From: Roger Spencer
Sent: 01 August 2016 18:24
To: Daniel Vick; Simon Davis
Subject: P/97/15/PL

Thank you for the opportunity to respond to the above application, including the 'Further Information...' document of May 2016 by ABPmer.

Figure H2. Location and Design of Proposed Breach and Channel Infill (Original Figure 2.2 of R.2446 Main Report)

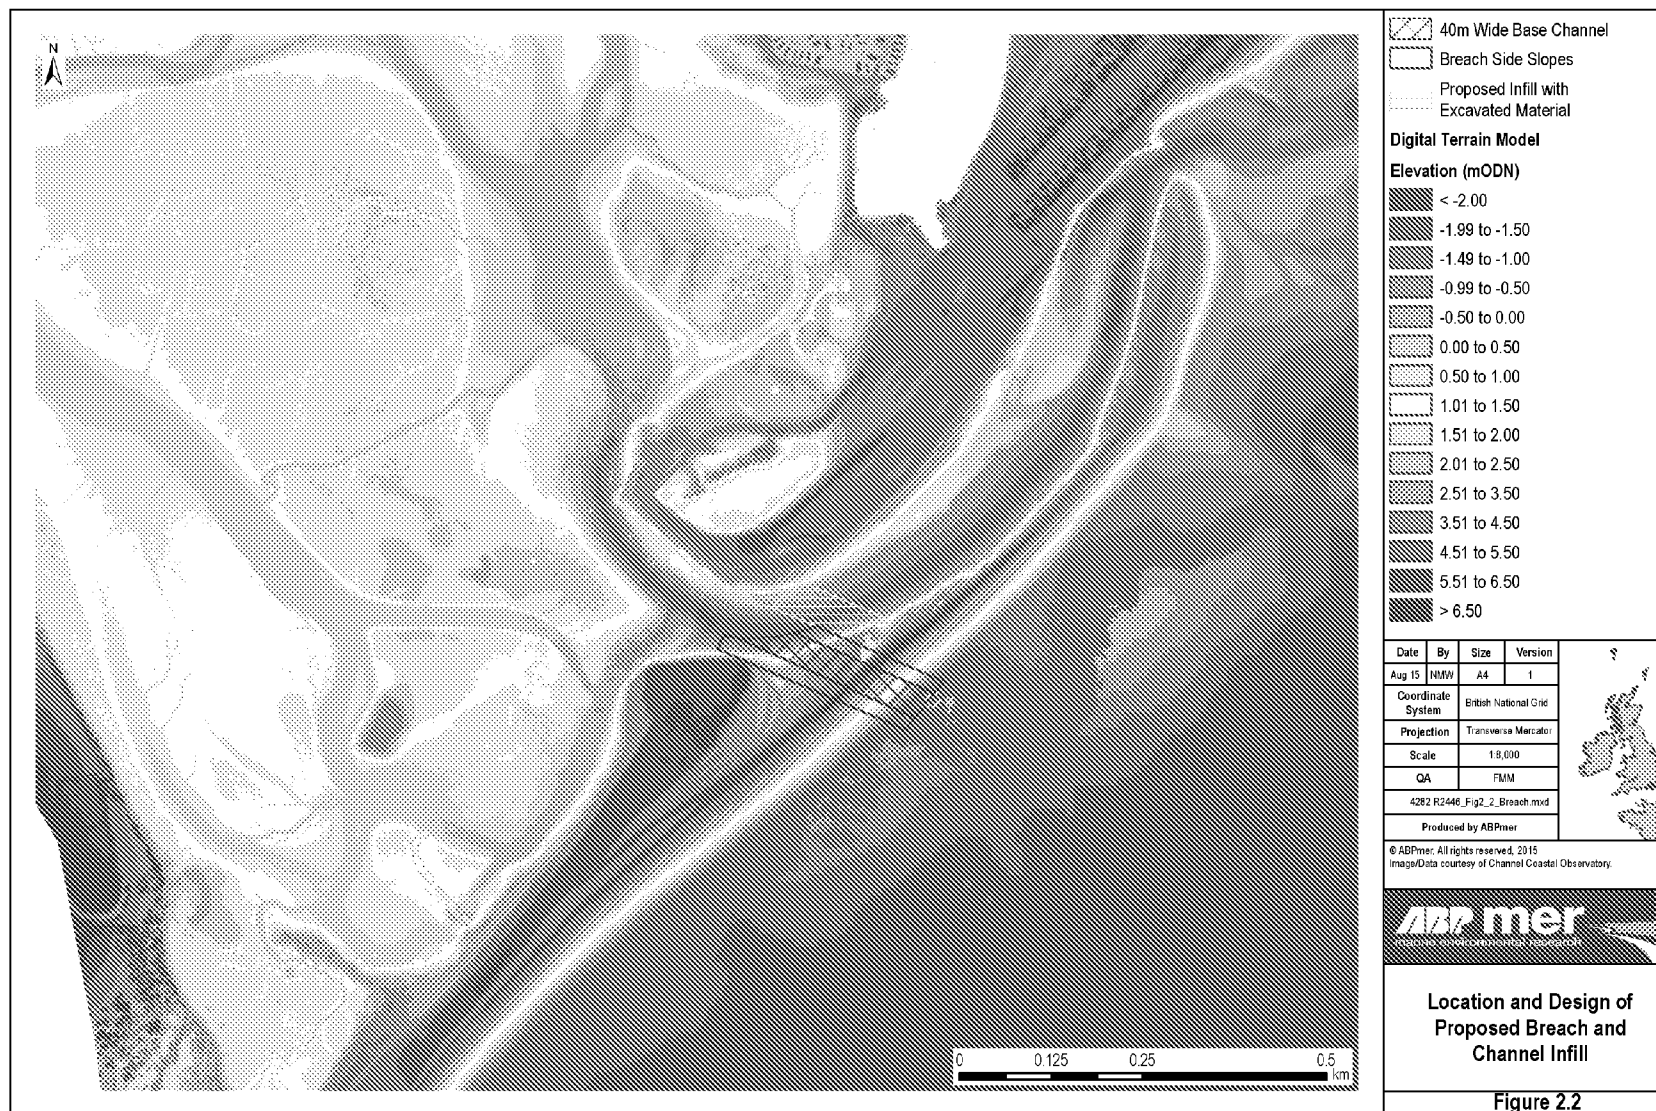
The Applicant has stated that it is likely that the channel will reach a natural equilibrium state within a few sets of spring tides. I am somewhat confused as to why a very formalised, designed cut is proposed and expounded as a viable solution for 8 years when the channel is likely to change in a matter of three months.

With the recent breach there is not only a redirection of the channel flow(s) but also a general lowering of the spit from the newly formed channel back towards the root of the spit (and the proposed cut location). By blocking the existing channel immediately inside the new cut, there will still be flow of water into, and wave action on, the gap between the severed part of the spit and main beach.

Construction methodology – the Steel sheet Piling (if required) crest is stated to be at a level of 0m OD and a toe at -3m OD therefore the piles would be 3m long. I do not think it would be possible to pitch and drive ~100m of piling over one low tide and even on a neap tide. The flows in and out of the harbour would be accelerated through the unconstructed portion of the dam, increasing flow velocity and scouring, both to make the channel deeper and progressively wider. A similar channel dynamic has been experienced here previously, between the growing spit and the fixed groyne. The channel would tend to migrate beyond the free end of the piling leading to a potential for uncontrolled loss of the spit. This is not to say that a blocking of the existing channel isn't possible but I would caution against the proposed methodology – perhaps, but not limited to, using rock bags that could be prepared and deposited in layers over a few tides. To form the working causeway – the problem with that being the sourcing of the raw material to fill the bags.

The process of stockpiling material dug from the new cut arrangement will have to be considered very carefully now that the spit has breached. The area of the connected spit is becoming increasingly small and may not be sufficient to hold the material dug before it is pushed into the channel to form the block. The Application does not include for rebuilding the spit to enable a stockpile to be formed. We have recently received laser scanned data for the beach

Mitigation/compensation – it is reported that other interested parties are now satisfied with the arrangements for providing compensation. I do not believe that the proposal to dig the separating channel to -0.5m OD will mean that the island will be an island at all states of the tides; thus predators will be able to gain access to the new tern habitat.
